**Essex County Council (ECC) - Written summaries of
Oral submissions made at Issue Specific Hearing (ISH) 1 and 2 (2 April to 8 April 2025)**

ISH 1 (2 April 2025 to 4 April 2025)

Figure 3: Archaeological results overlaid on APS data showing NMP data for comparison

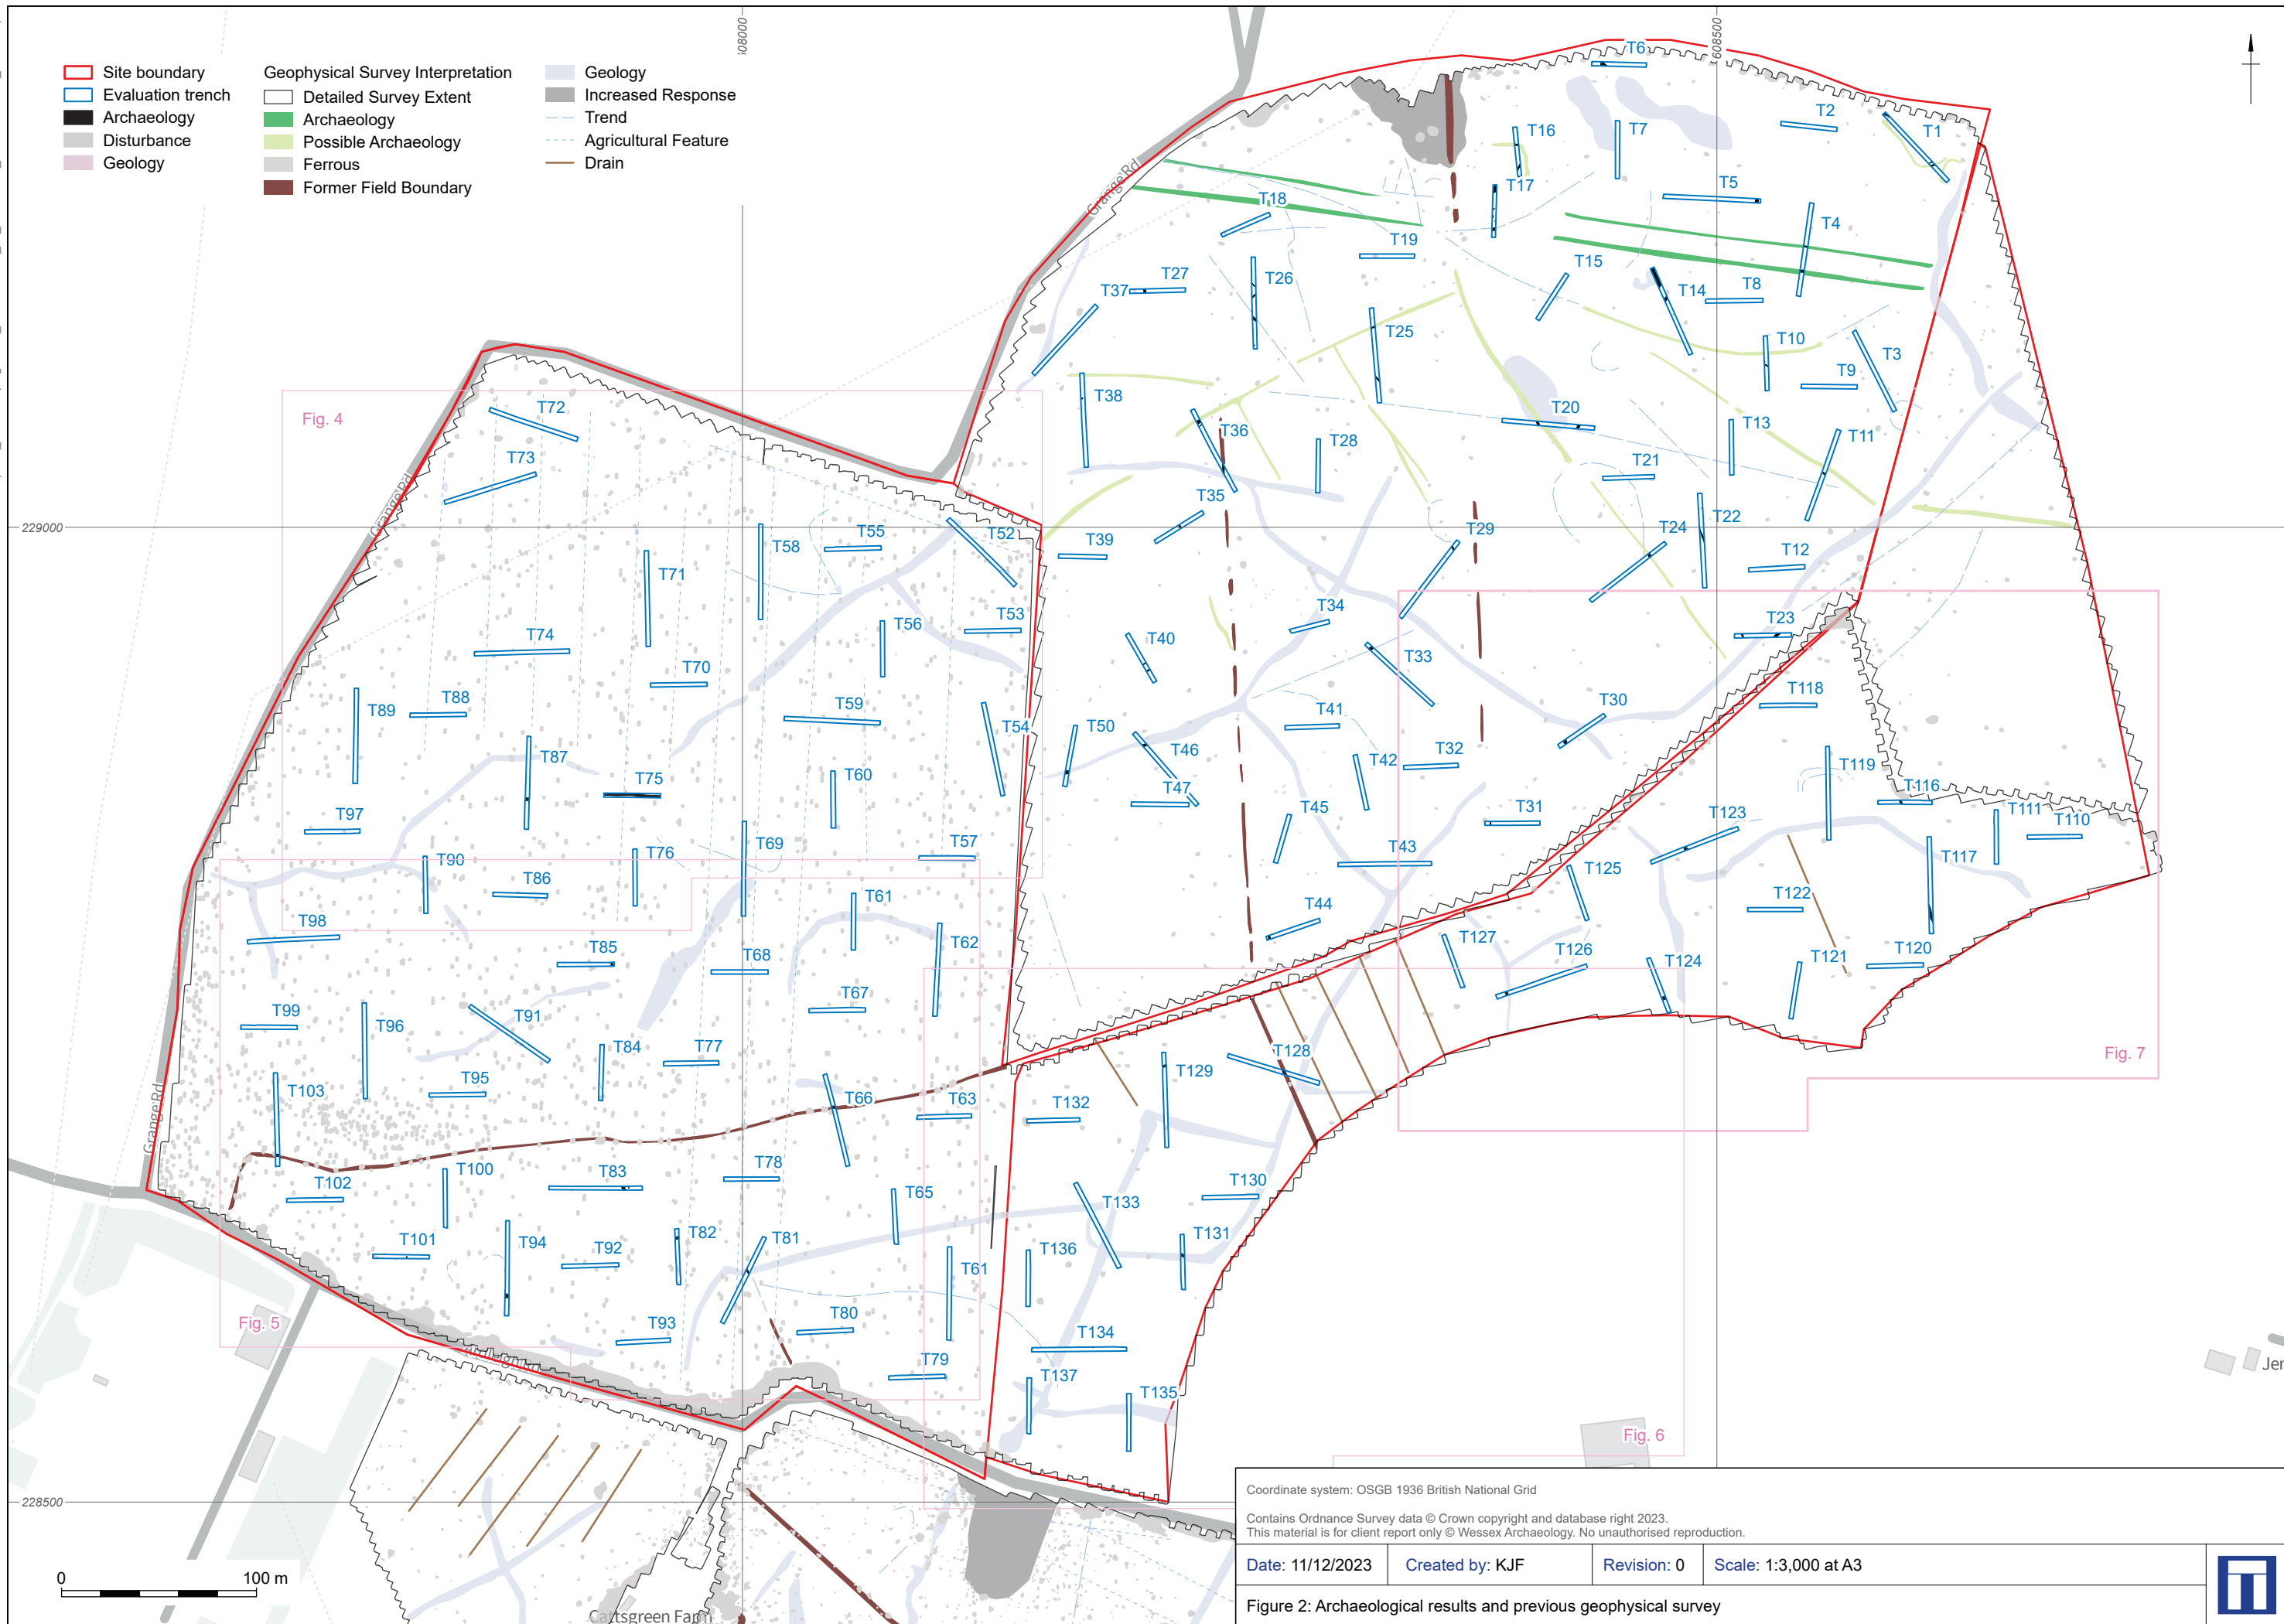
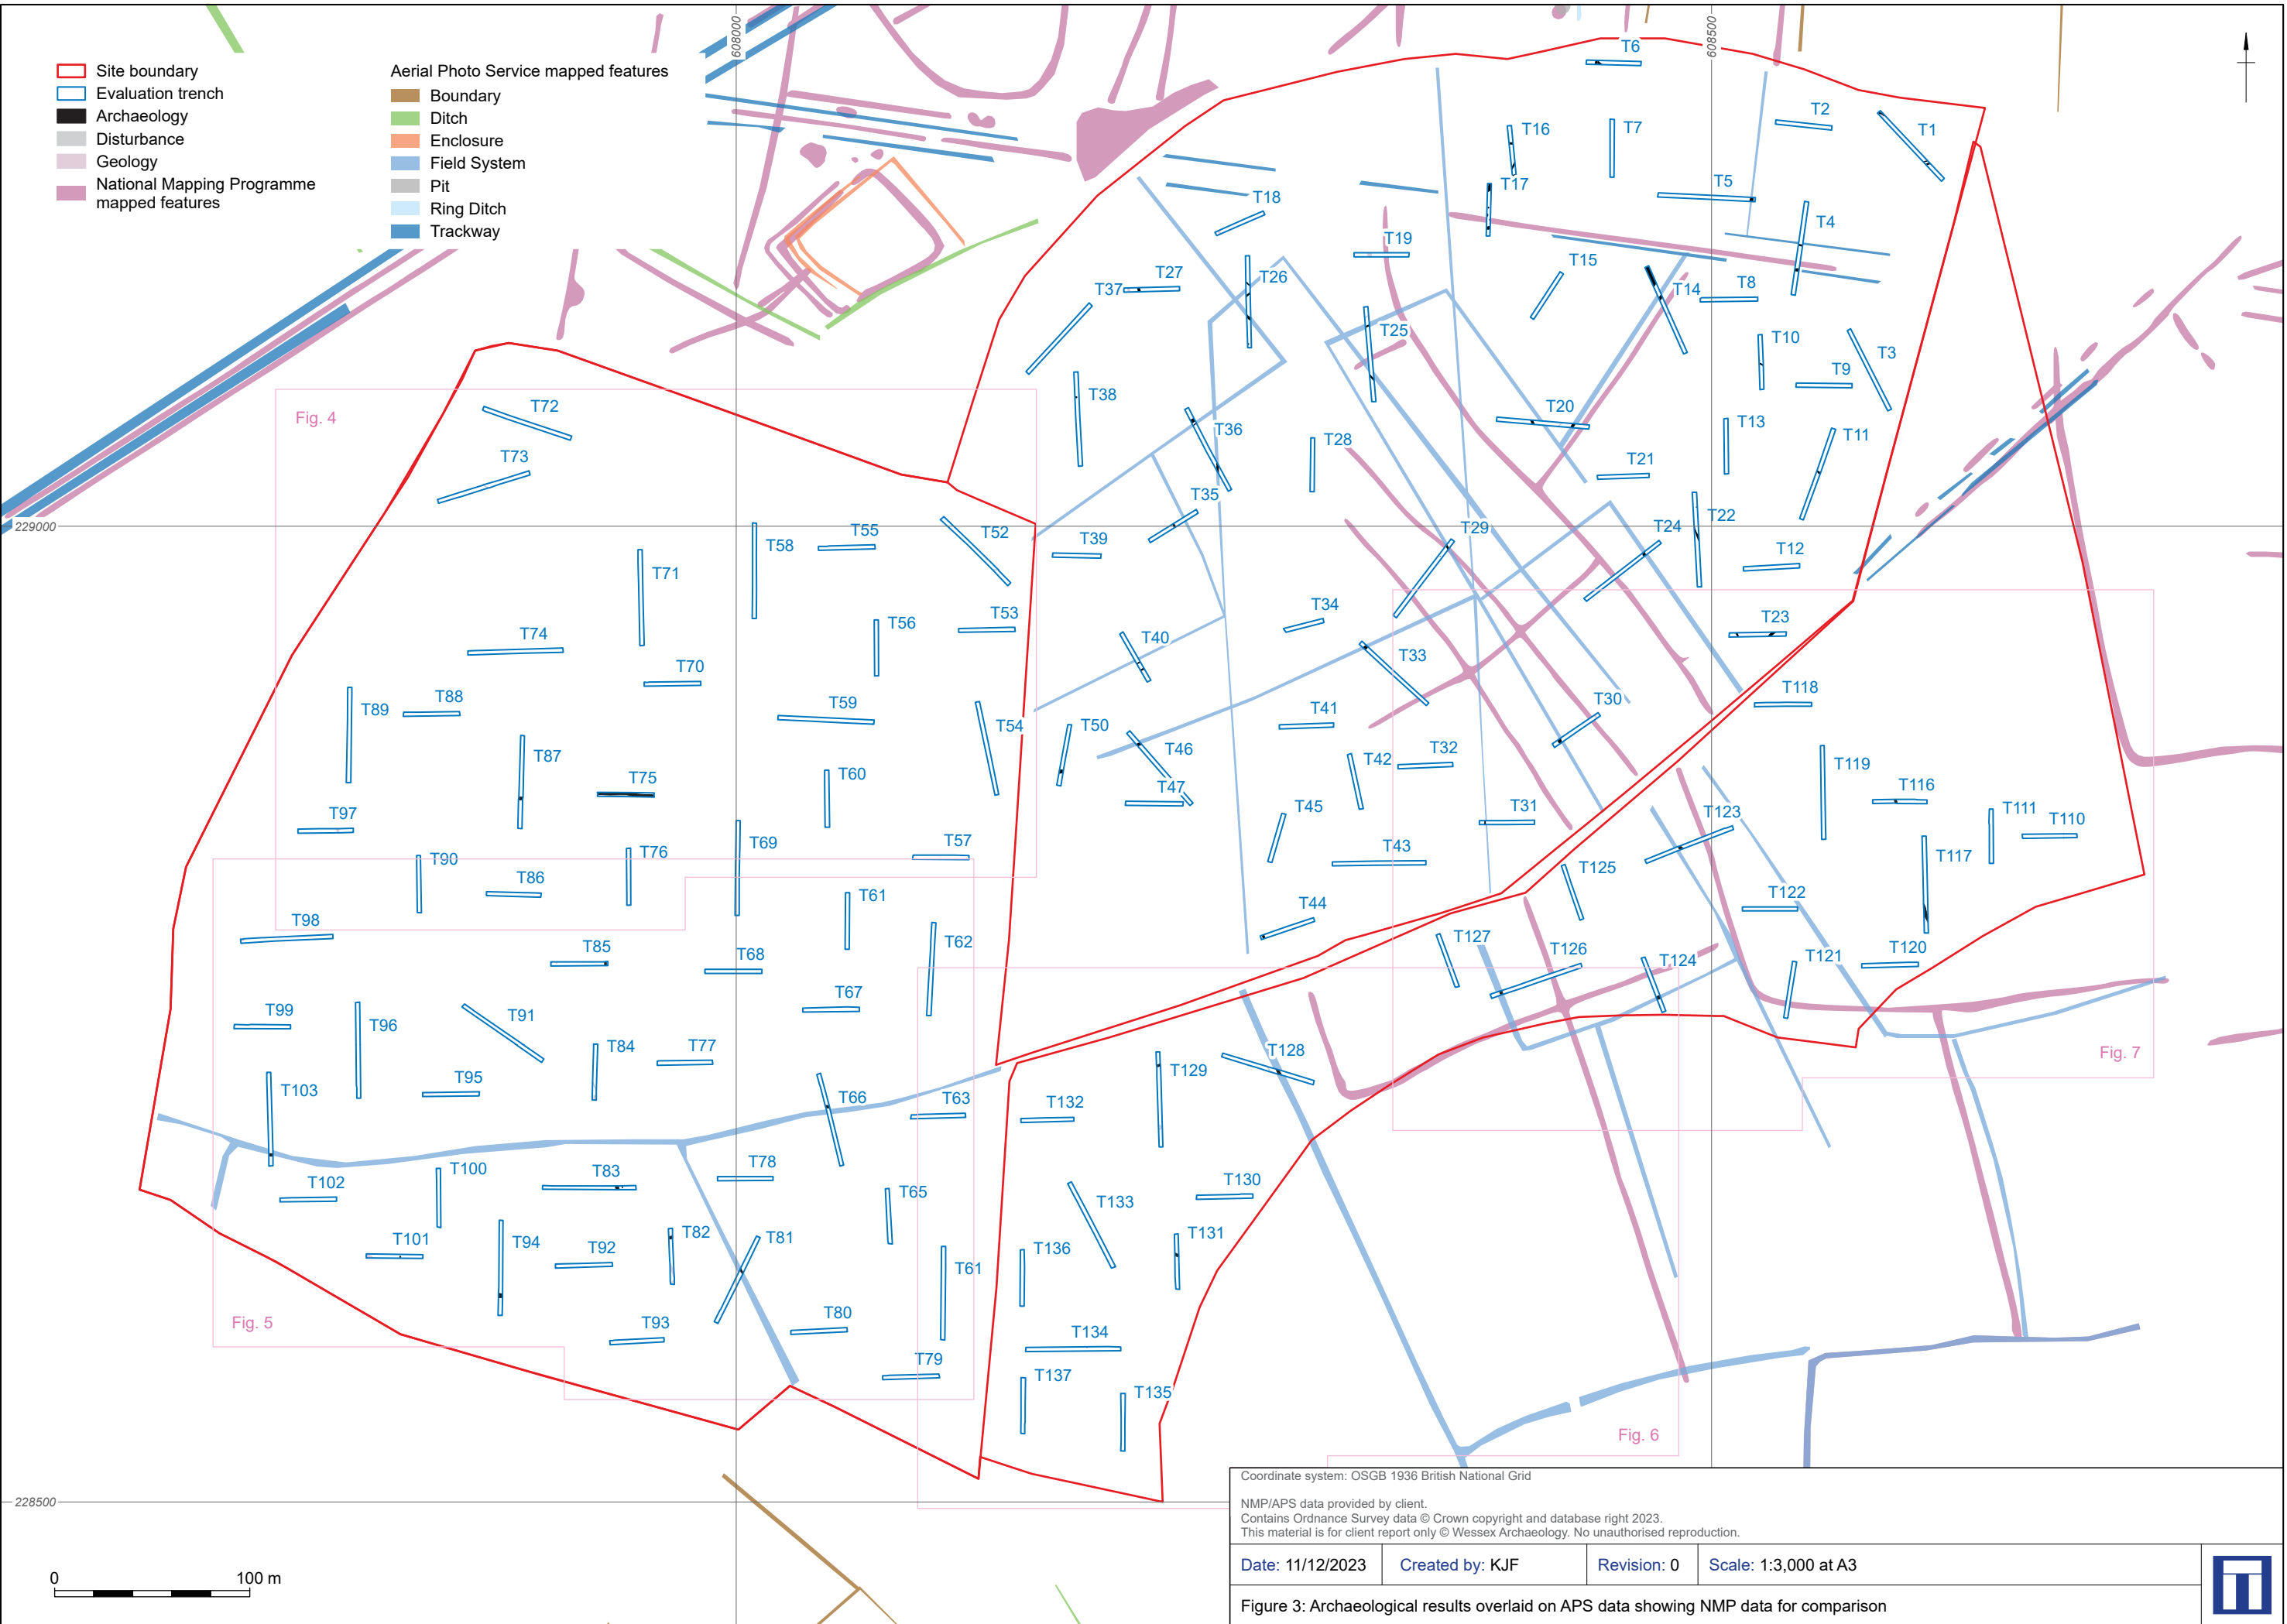
The archaeological heritage assets listed in document APP-039 have been largely identified through desk-based research and non-intrusive methods. These methods can only provide an indication of the potential for archaeological features. A geophysical survey is dependent on the receptiveness of the soils and geologies and a number of other factors in its effectiveness to identify below ground archaeological remains. It would not be able to provide sufficient information on the significance of any potential archaeological deposits located below ground. This is almost impossible to state with confidence, in terms of what the applicant consider significant in terms of EIA. Without a level of trial trench evaluation verification is not possible.

For the two areas that have been trial trenched, some areas did correspond with the geophysics, but other areas there were features that were not picked up by the geophysics. So we do not have enough information from the trial trench evaluation that have taken place to date to state, again, with confidence, that the non-intrusive methods that have been carried out so far are providing a reasonable account of what archaeology maybe within the development area and what archaeology may be impacted.
